Application: SSI 7485

I write regarding the proposed modification to M4-M5 Link, Mod 2 The Crescent overpass and changes to pedestrian infrastructure in North Annandale, Rozelle and Rozelle Bay Foreshore area.

Figure 4-2 Pedestrian and cyclist bridge infrastructure options

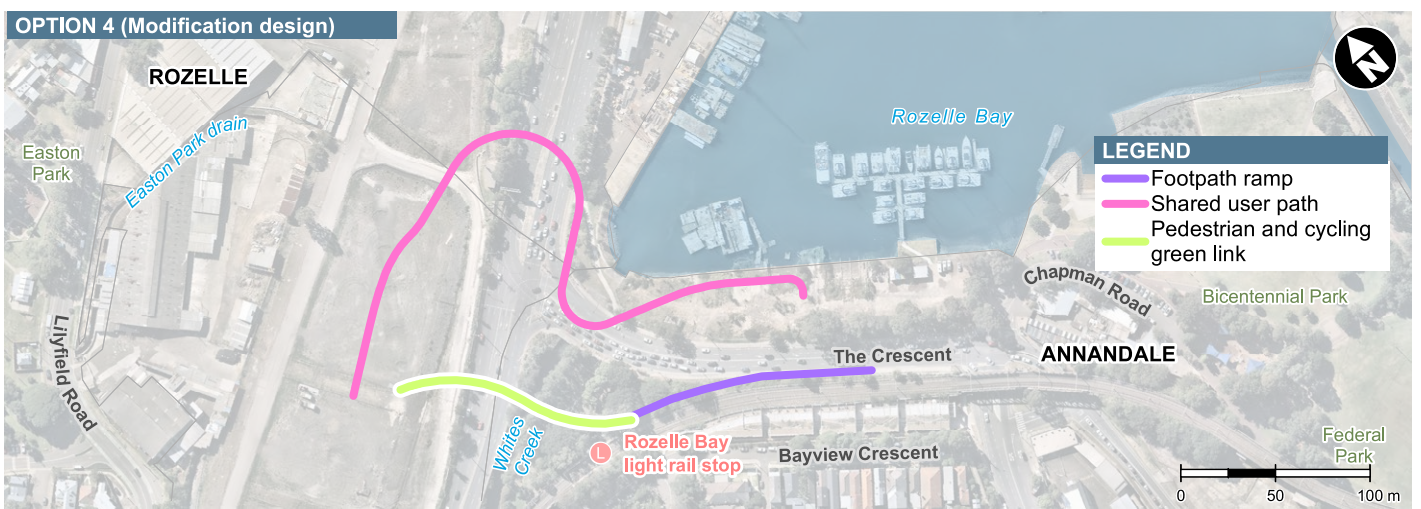
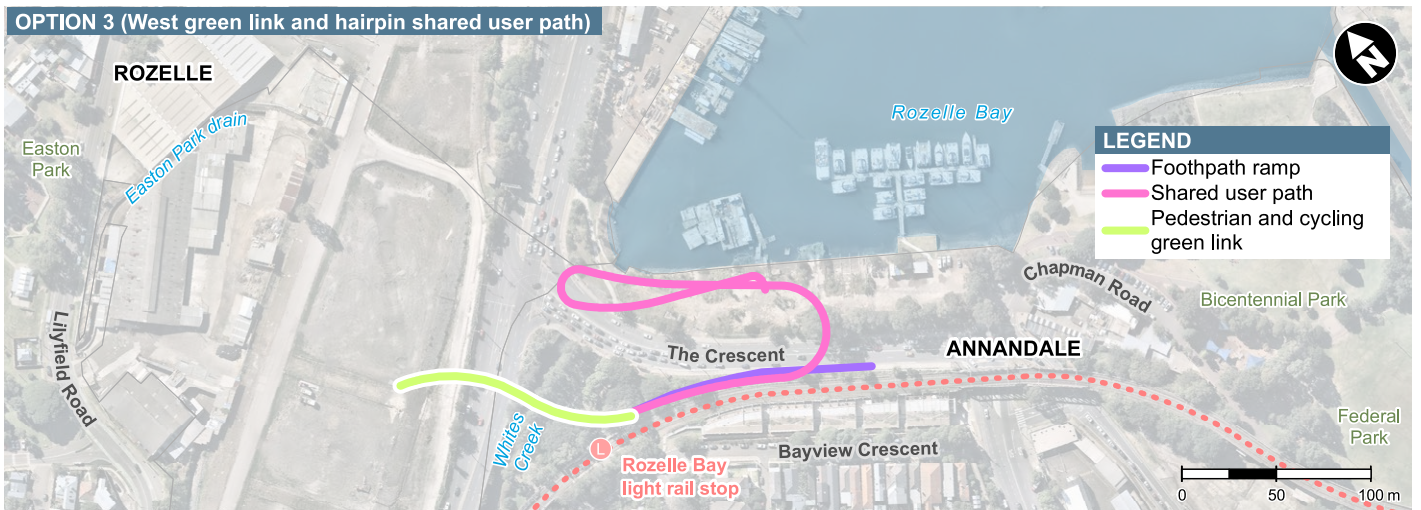
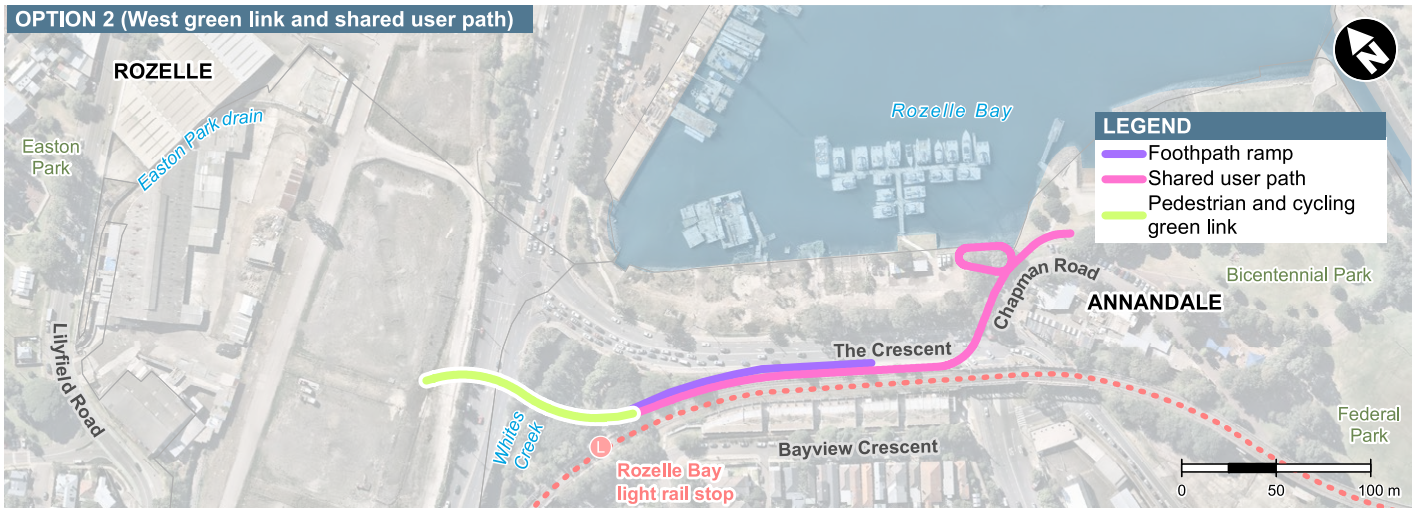
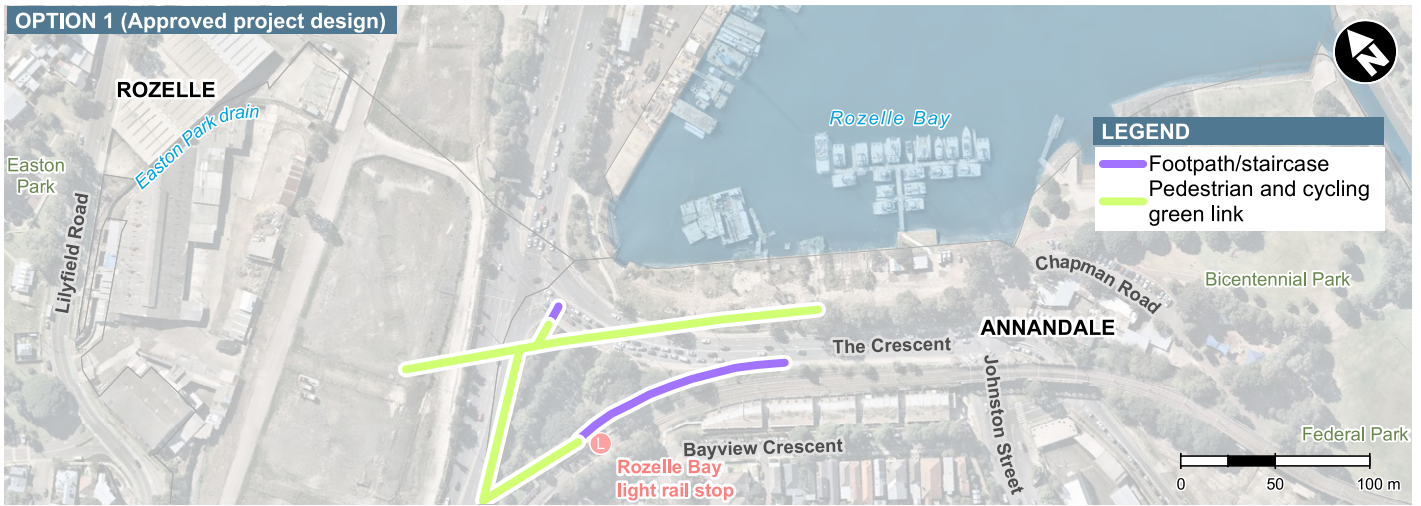
I request RMS work with the community to explore alternate design options to the proposed new car overpass design and the changed pedestrian and cyclist links. I am seeking the reinstatement of the safe, direct access from the approved EIS GreenLink to create a continuous green open space connection from the Rozelle Rail yards and Annandale to the foreshore. The GreenLink was more than just a walk way - it put people central to the design, maximising safety, and providing much needed accessible open space for the community now and into the future Bays Precinct design.

- The significantly reduced safety and increased risk for pedestrians and cyclists with removed access over The Crescent to Bicentennial Park and the increased traffic along Johnson Street.
- Being required to cross five sets of pedestrian lights at The Crescent as my option to reach the foreshore from Annandale or from Rozelle Bay light rail stop.
- Removal of direct active links to the foreshore, cutting the community off from the area and the proposed revitalisation of the entire Bays Precinct, including linking the Light Rail and Bus stops to a Ferry wharf and Metro station.
- Urban and landscape design that is being built before a finalised Masterplan for the area.
- Traffic changes that limit movements around the suburb and create further congestion in the local streets of Annandale, Forest Lodge, Glebe, Lilyfield and Rozelle with no planning to deal with these.

- Reinstall the GreenLink connecting communities and green open space from Rozelle to Bicentennial Park
- Relocate and design pedestrian and cyclist connections that are continuous, safe and direct.
- Design the modification infrastructure and active links in response to the character of the suburbs, the location of the foreshore and its potential future development.
- Provide pedestrian and cyclist paths that maximise people safety and do not force them onto busier streets, unsafe concrete plazas and caged walkways.
- Integrate active and direct connections to all active transport – including the future Metro West and Foreshore Ferry Wharf

Figure 4-4 Elevation: Indicative view of The Crescent overpass

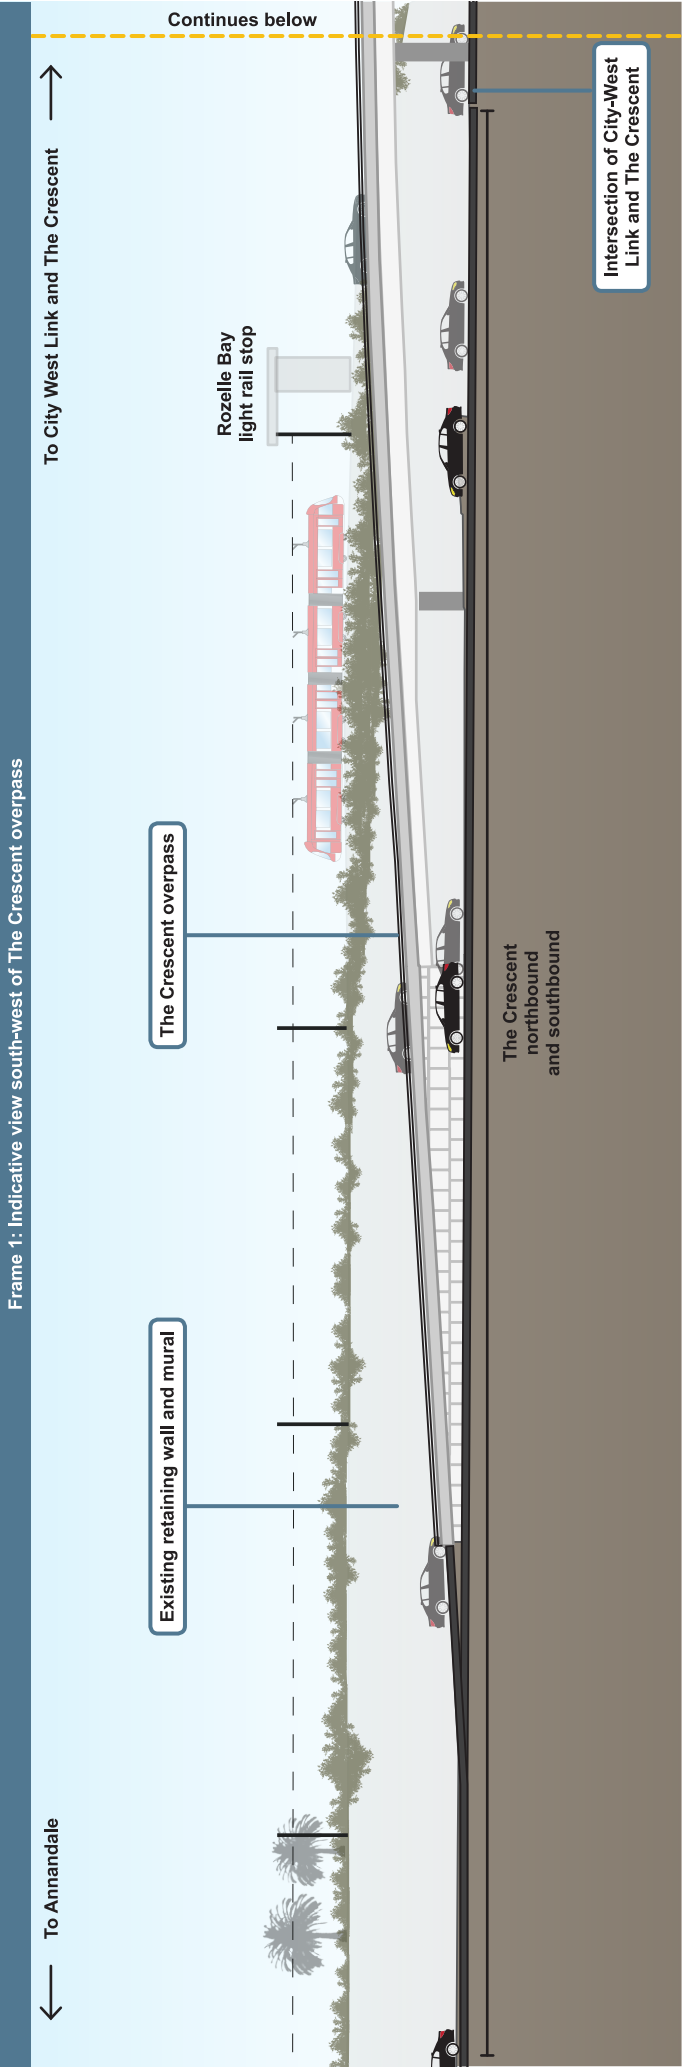
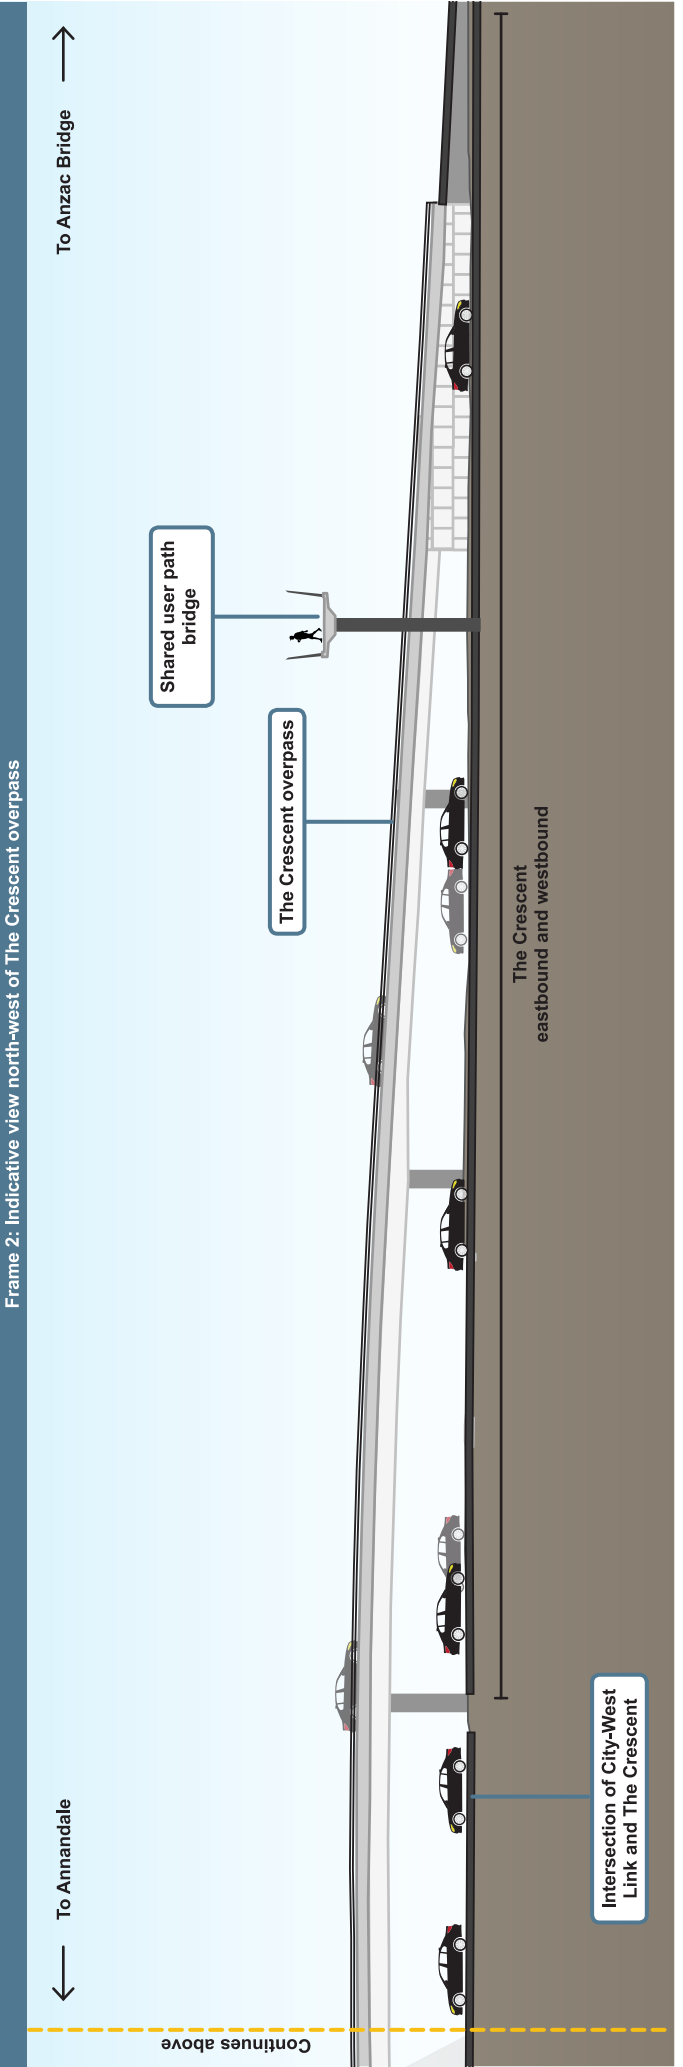
- That the modification will be a major visual eyesore that greatly detracts from the currently attractive views of Rozelle Bay
- That RMS continues to give little consideration to non-motorists in its planning decisions
